ENG-SF20015-R4-Plat.pdf Markup Summary

FINAL PLAT

FINAL PLAT
STERLING RANCH FILING NO. 2
JOB NO. 25188.01
9/22/2021
SHEET 4 OF 6
FILE NO. SF-20-015

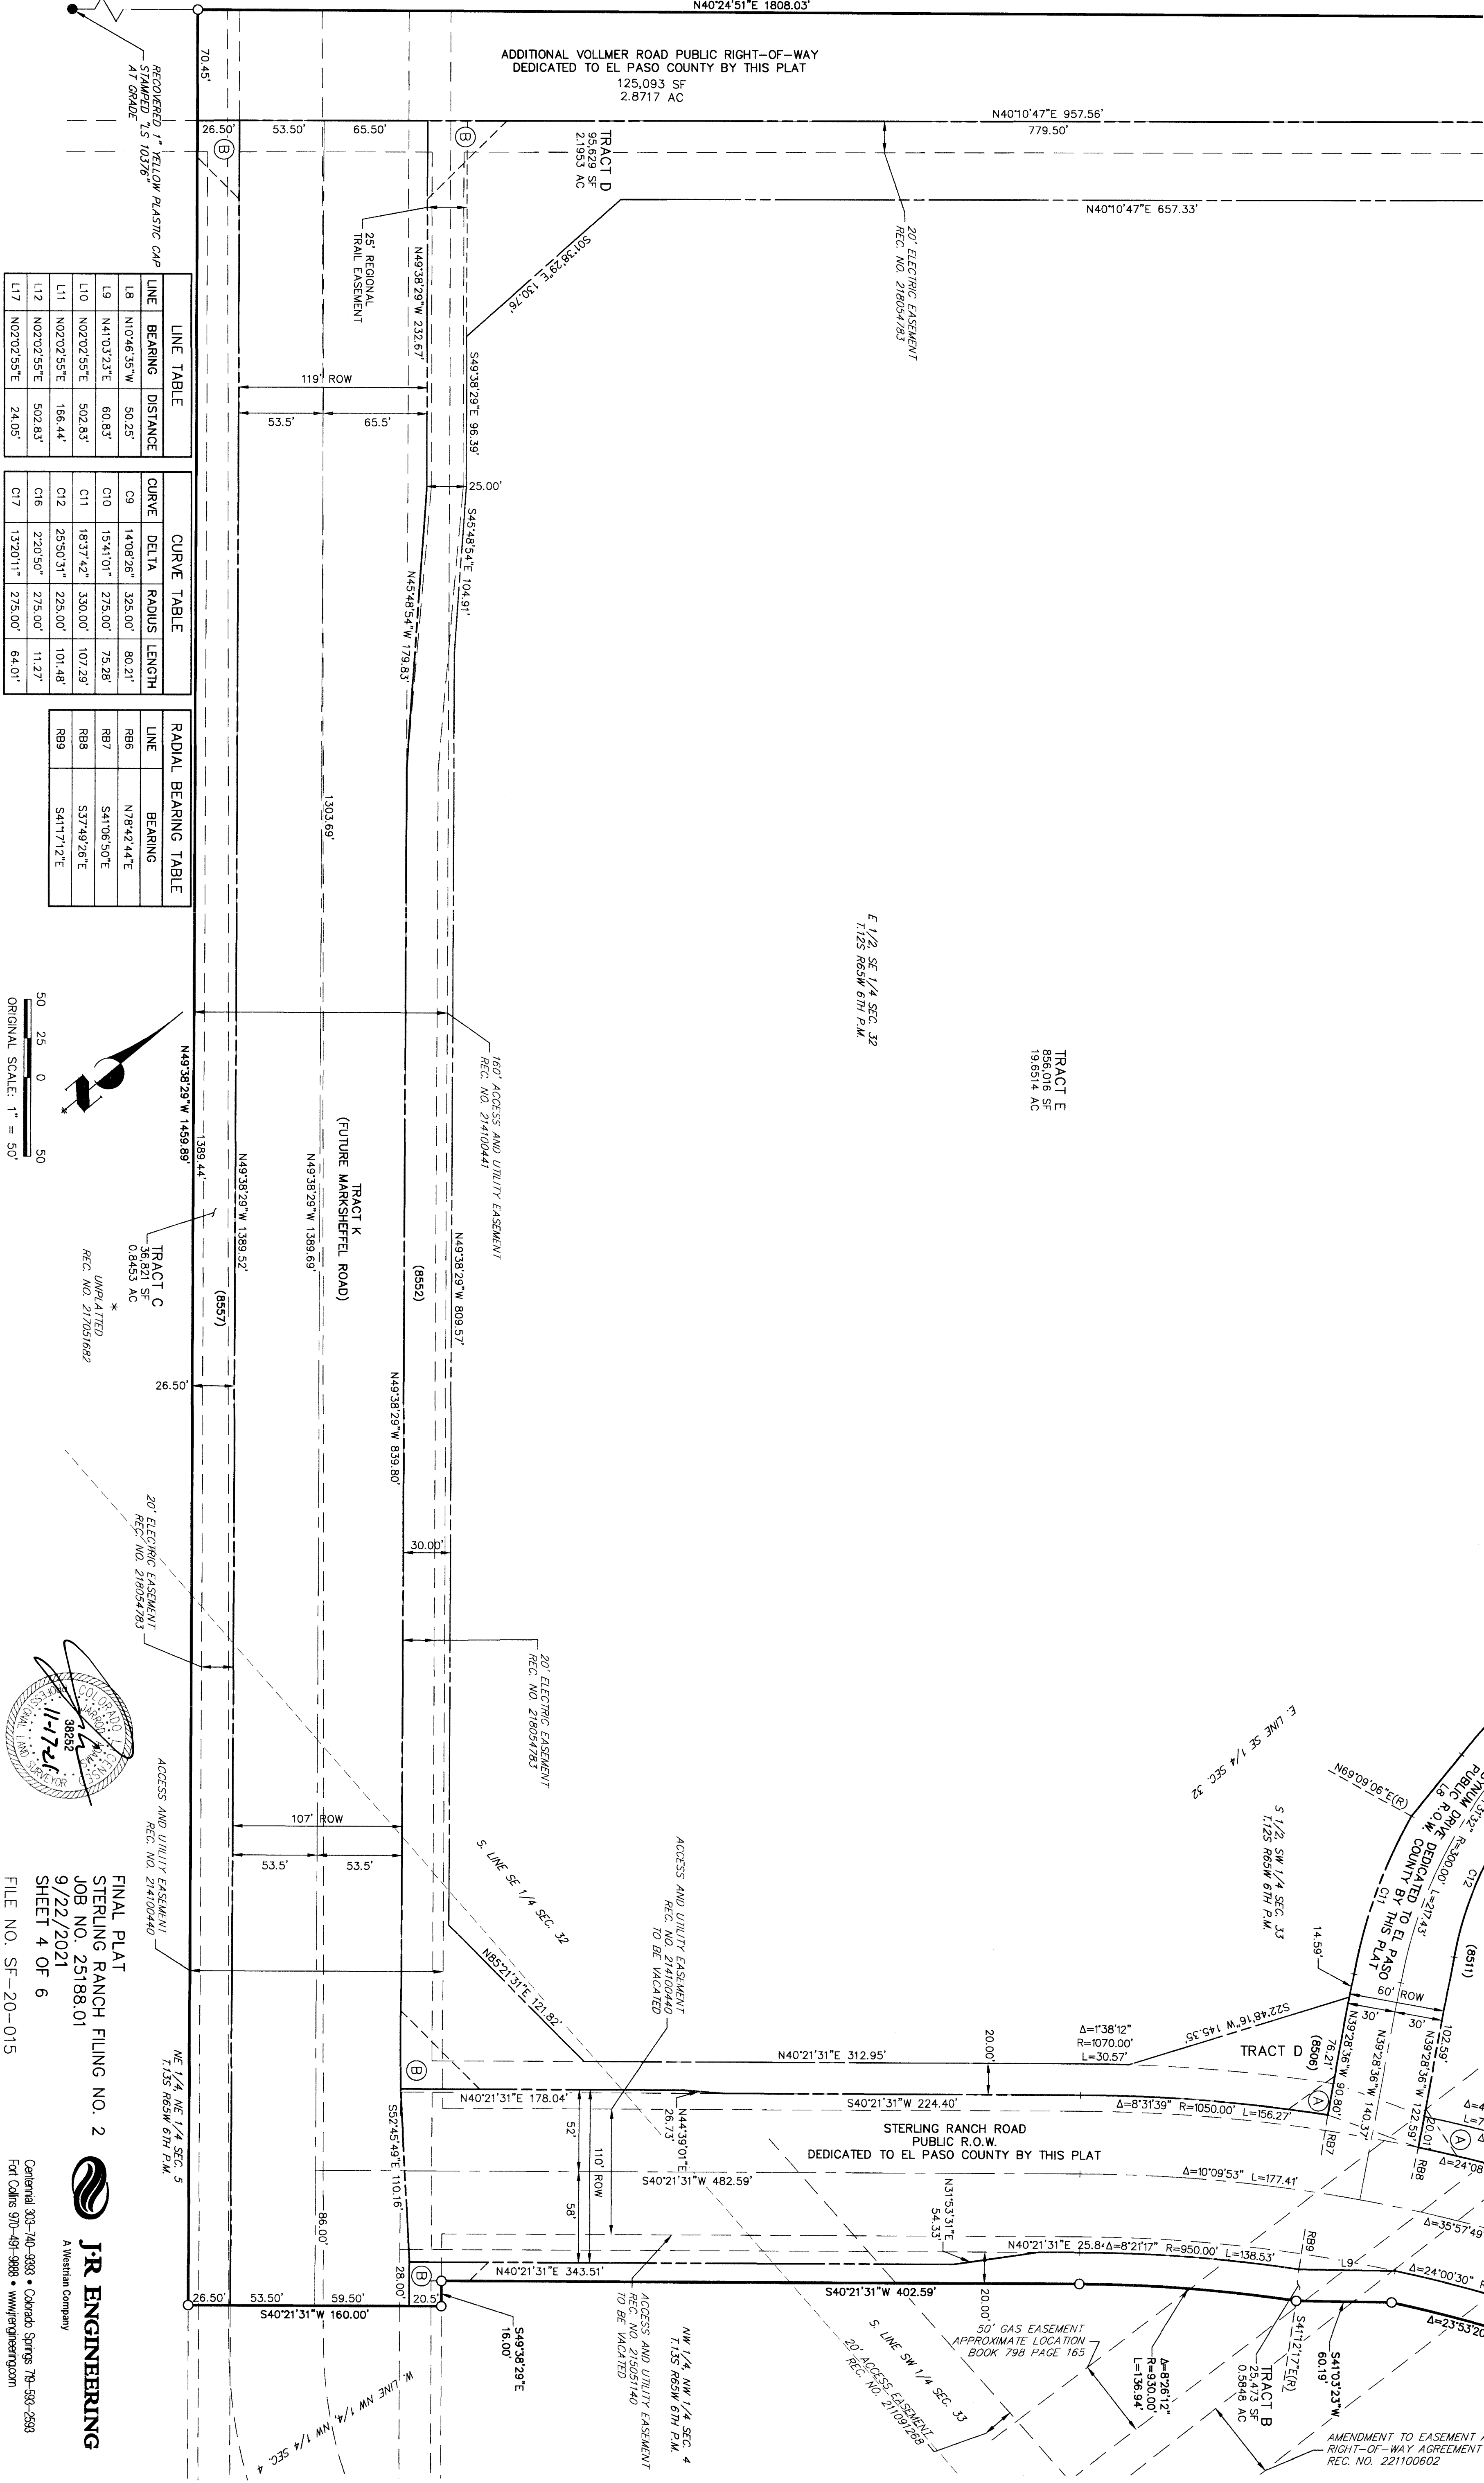
Add: Noise wall to be built by developer , maintained by District along Vollmer Road

Add:
Marksheffel Road will not be accepted or
maintained by El Paso County.
